Rezoning Petition Review

Rezoning Petition #: 20-70

Location of Property: Approximately 5.8 acres located on the south side of Bullard St, the north side of Joy St and west of Ashely Rd.

SHEET NUMBER  
**RZ-1**

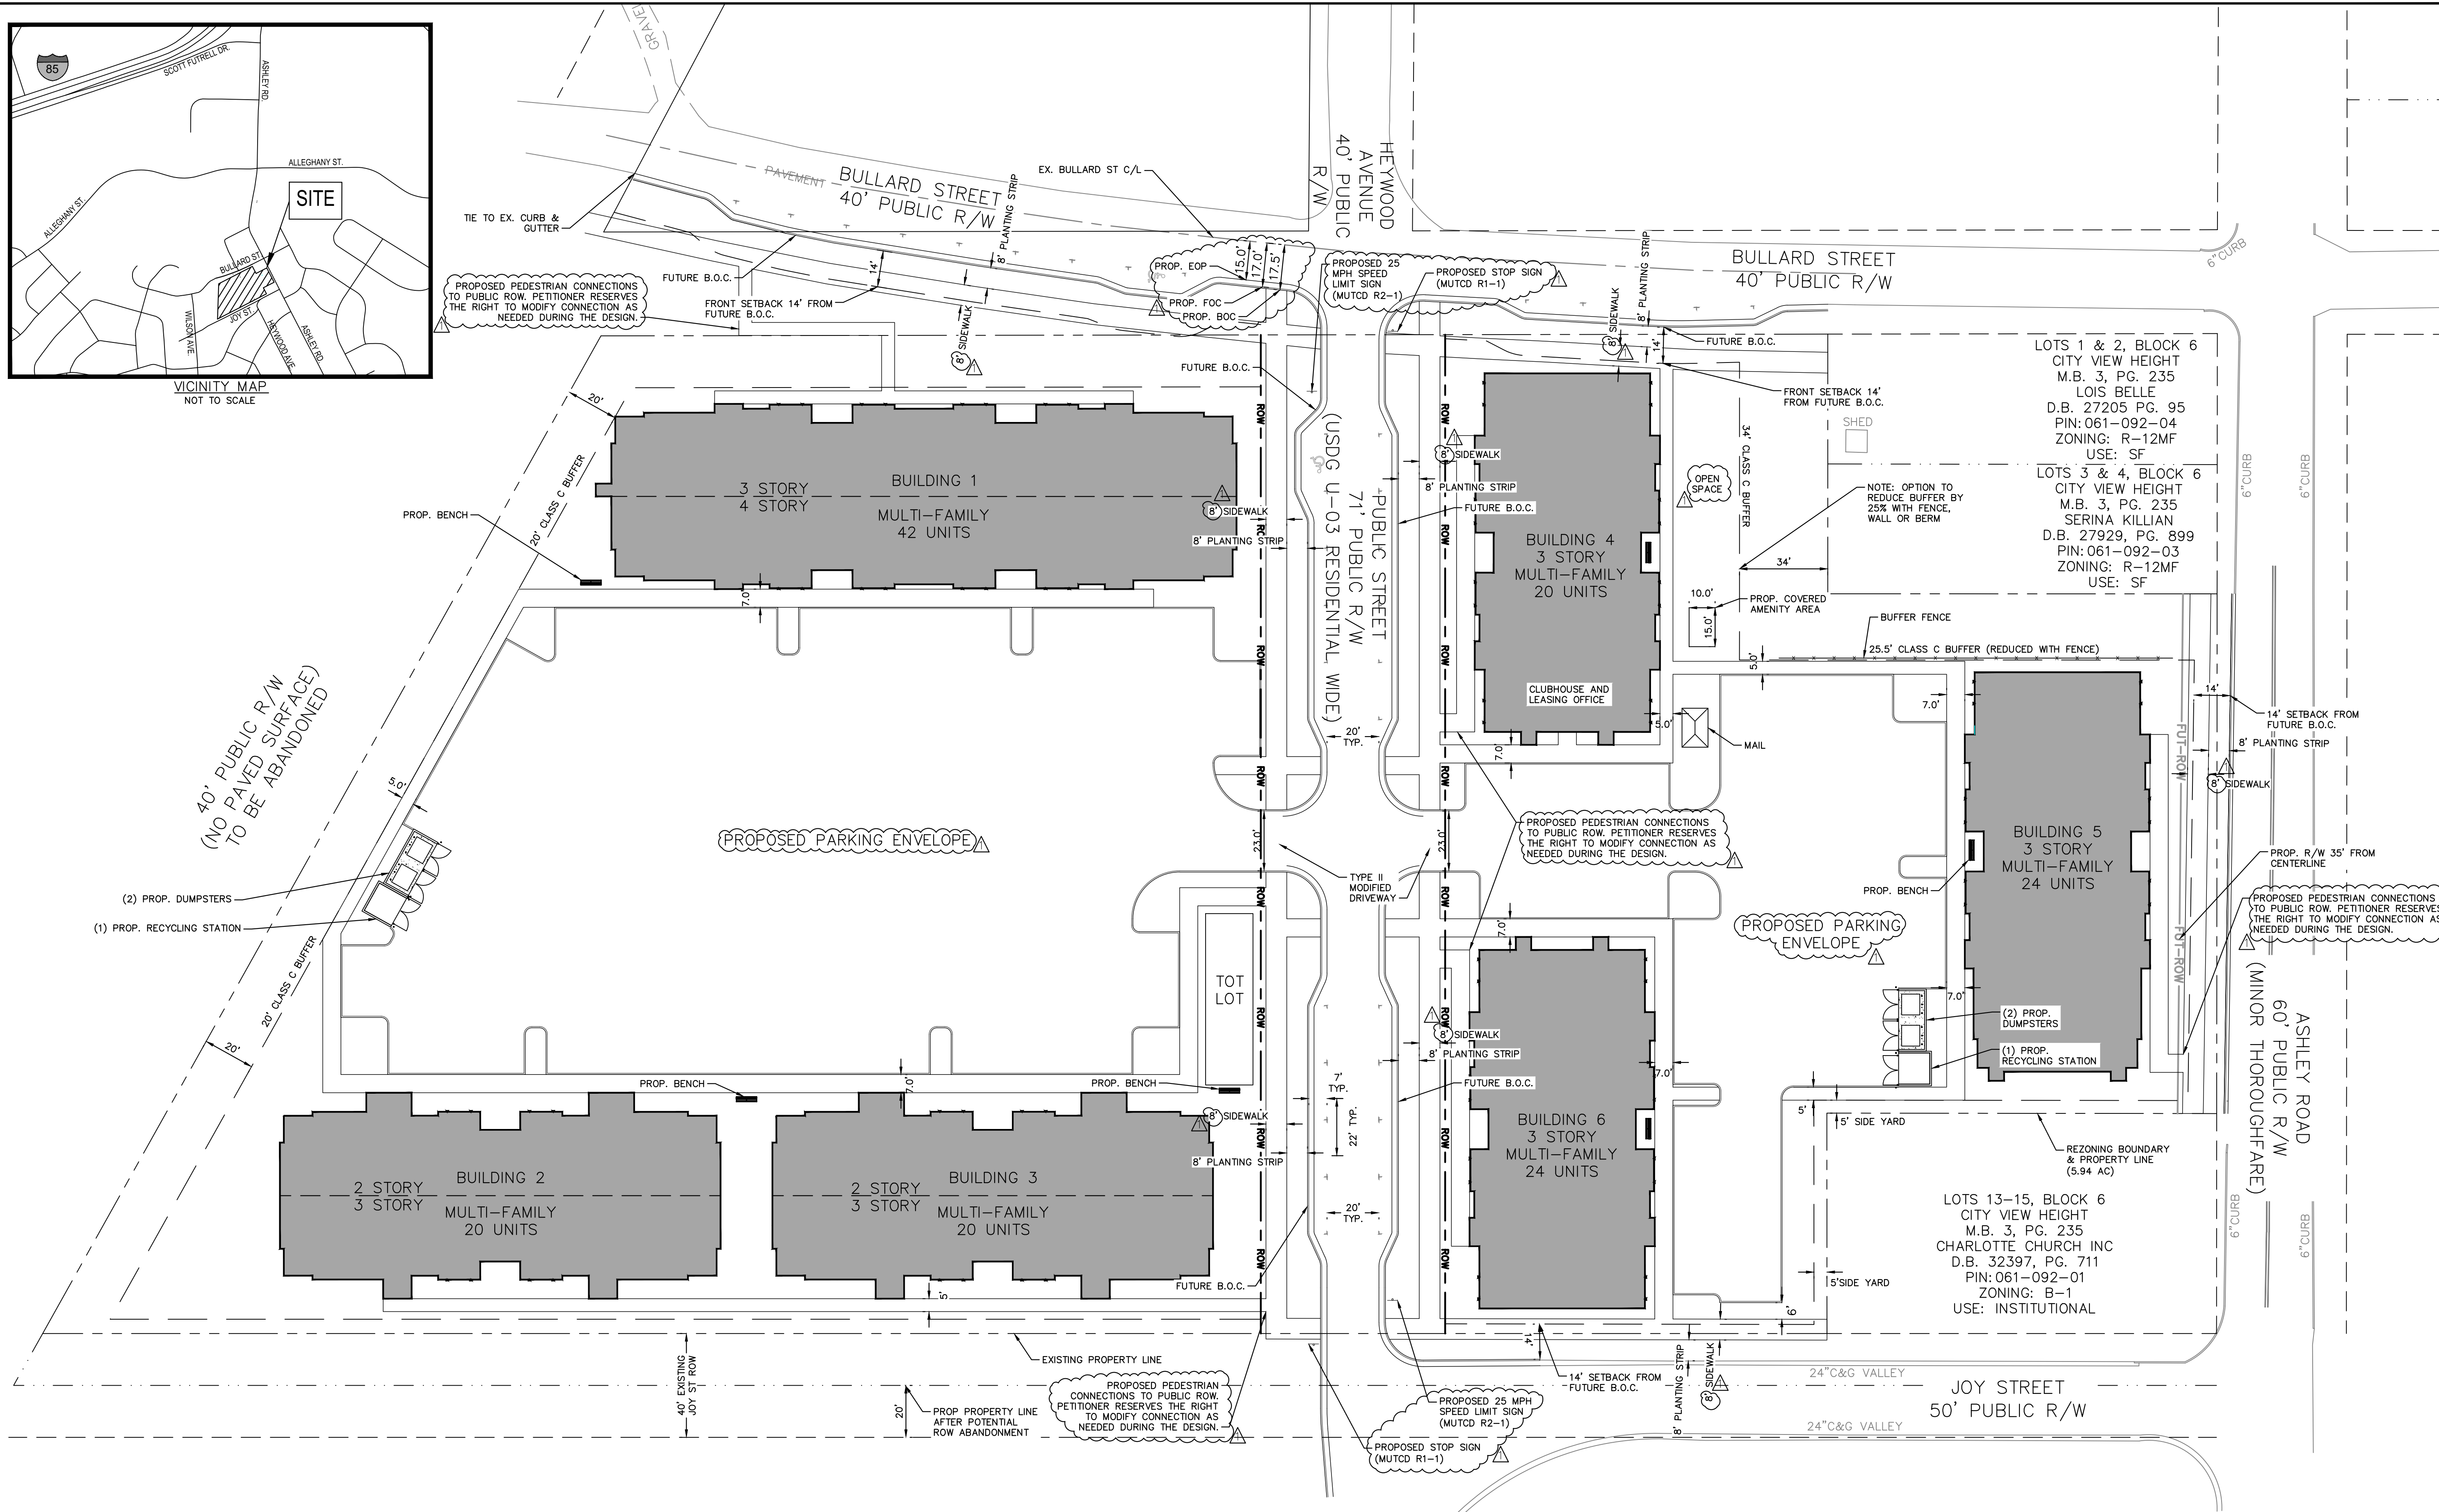
Due to revisions (6/19/20): Please include the following note under Environmental Features. *For adjoining parcels receiving storm water discharge the petitioner shall analyze the adequacy of the existing storm water conveyance on the adjoining parcels to the nearest improved public RW (downstream of Joy Street). If the existing storm water conveyance on the adjoining parcels is found to be inadequate, the Petitioner shall make a good faith effort with the property owner(s) to improve the storm water conveyance or mitigate the storm water discharge onto the adjoining parcels.*
